# Glen Innes WindPower Pty Ltd

3 July 2014

## **RE: Response to submissions relating to MP07\_0036 Mod 2 (Glen Innes Wind Farm)**

FIGURE 10: Theoretical Shadow Flicker Duration to 2000 metres (Approved)

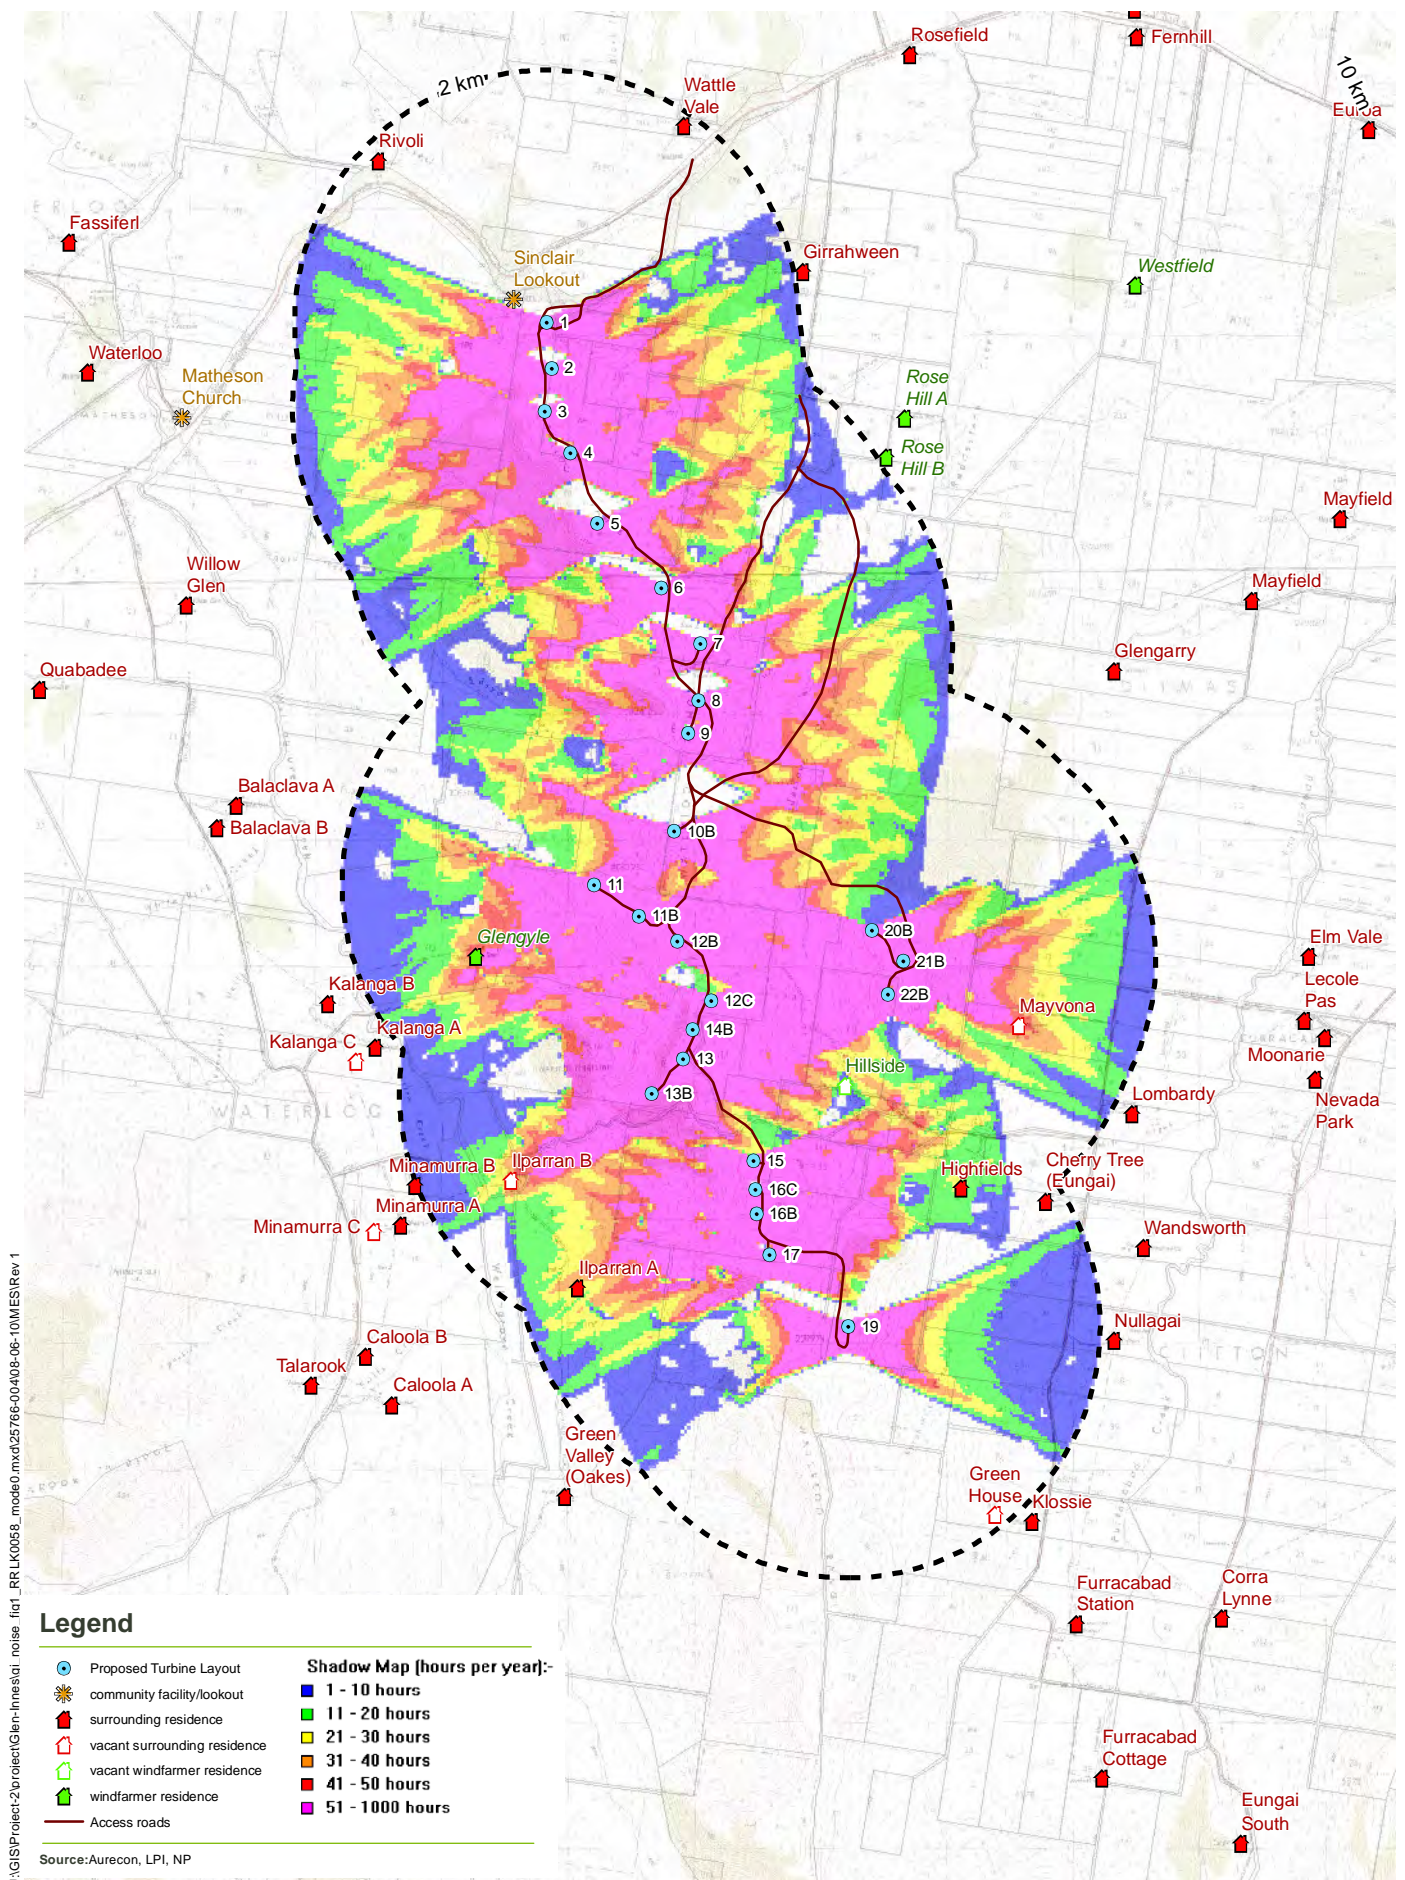
11.23	<p><i>The report by Aurecon states that the Shadow Flicker caused by the proposed new turbines will exceed by 30 hours, the acceptable limit, at 2 non-associated wind farm residences - Mayvona and Ilparran B. However there is also increased shadow flicker at other residences.</i></p>	Mitigation measures are in place with Ilparran property owner and currently Mayvona is unoccupied (derelict). The other two residences that show increased flicker are still below the 30 hours. Mitigation measures are available as stated in the EA approval document.

Figure 4: Proposed turbine locations

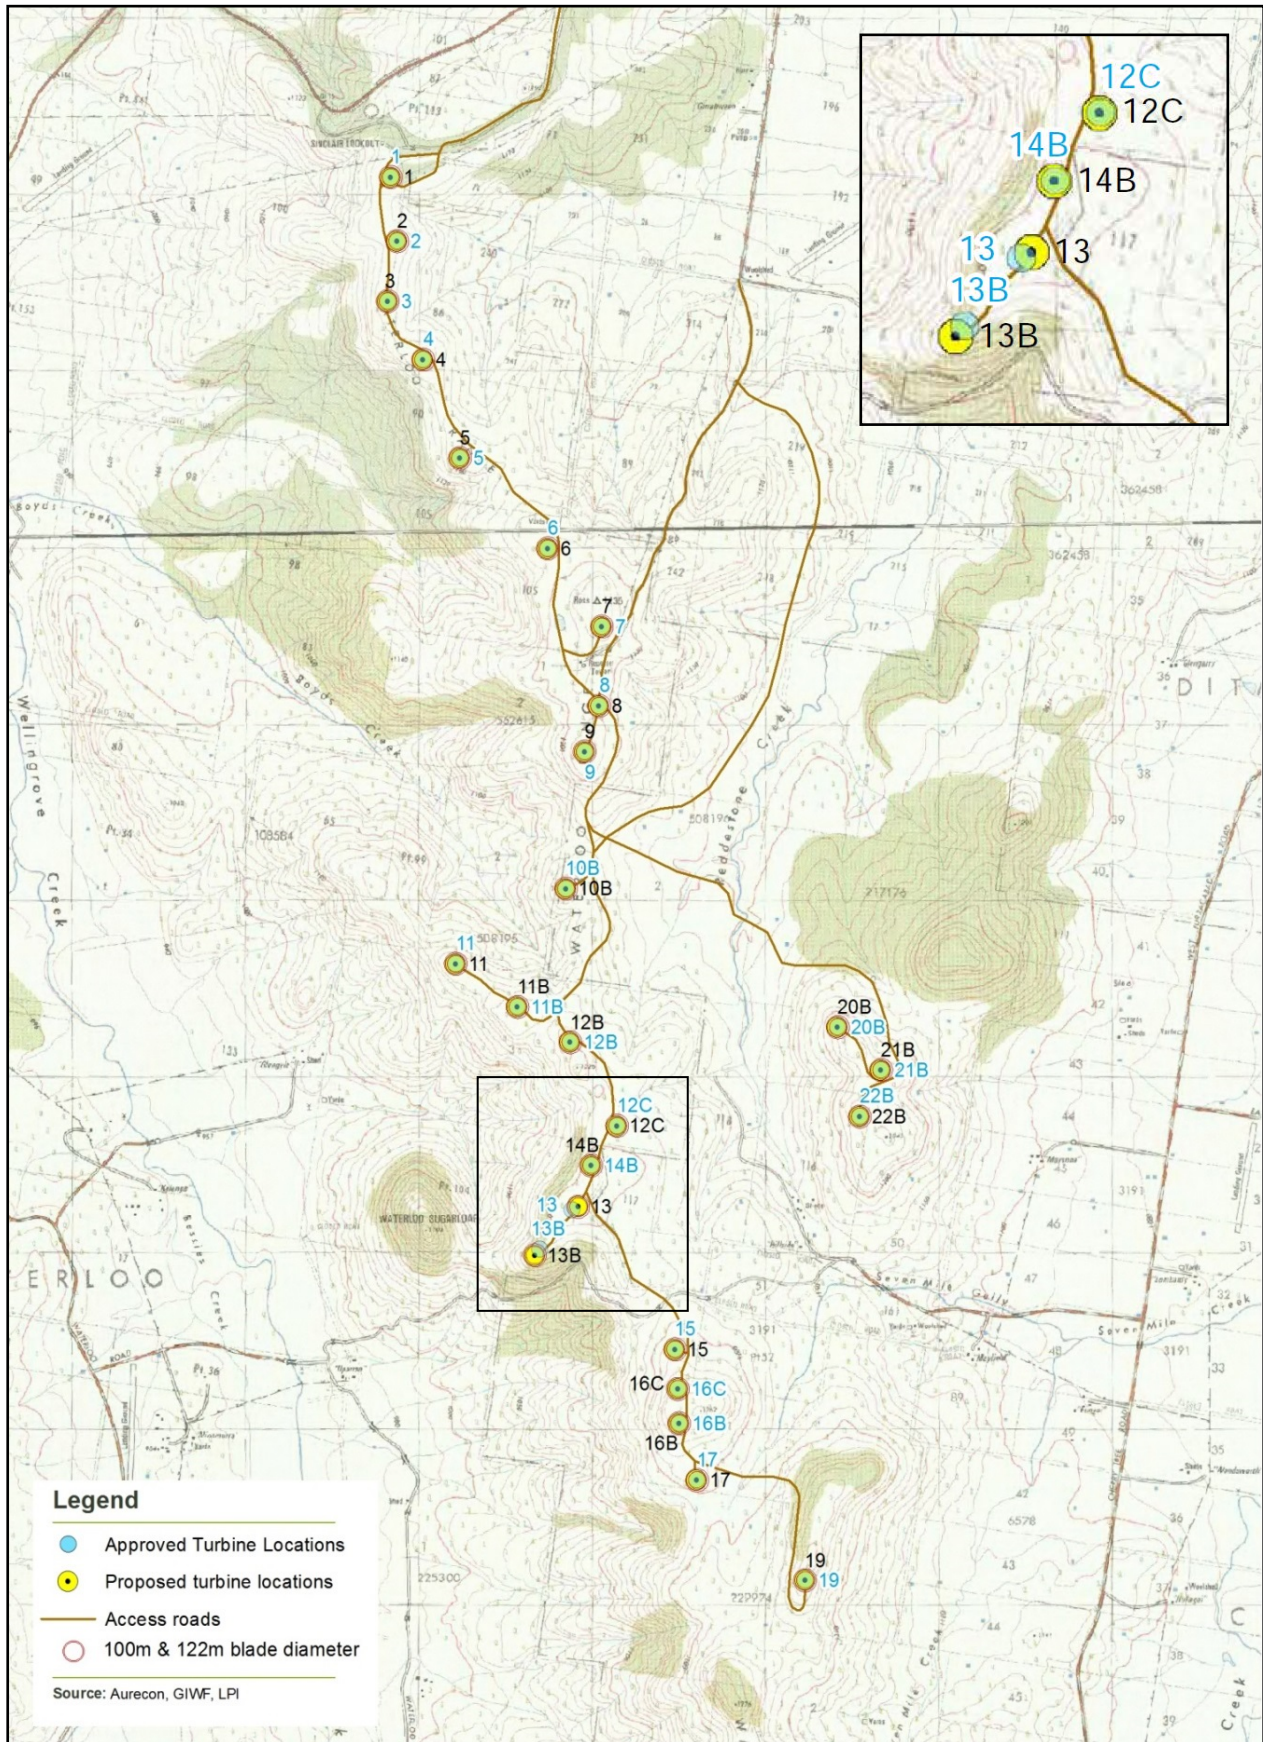
11.10	<p><i>Micro sighting of turbines was not allowed in the original approval (viz: 2009 year).</i></p> <p><i>GIWP are claiming micro sighting is allowed under the Draft NSW Planning Guidelines: Wind Farms 2011 however the Wind Farm was not approved under these guidelines. Either the original approval conditions must be applied or GIWP "leave" the old approval conditions and apply and transfer their approval to the Draft NSW Planning Guidelines: Wind Farms 2011 "in their entirety" which GIWP are not doing. GIWP cannot "cherry pick" which of the draft guidelines they wish to apply/comply with and those they do not want to comply with – it is either all or none.</i></p>	<p>Micro-siting has always been allowed under the planning guidelines (both those used for the project approval, and the Draft Guidelines issued in December 2011). It is Industry Best Practice to site the turbines in the most effective, efficient and environmentally acceptable positions.</p> <p>A small degree of movement of turbines is considered acceptable to allow for slight variations during construction such as ground conditions, or adjustment to allow for easier installation.</p> <p>Any micro-siting undertaken would be consistent with the terms of the project approval, and would ensure no additional environmental impact.</p> <p>A recent condition imposed in the project approval for the Flyers Creek wind farm is</p>

<b>Issue raised</b>	<b>GIWP Response</b>
		<p>considered a suitable clarification of the micro-siting, and GIWP anticipates that a condition of this kind will be added as an additional requirement to the modification approval.</p> <p>See comments in item 11.3 above.</p>
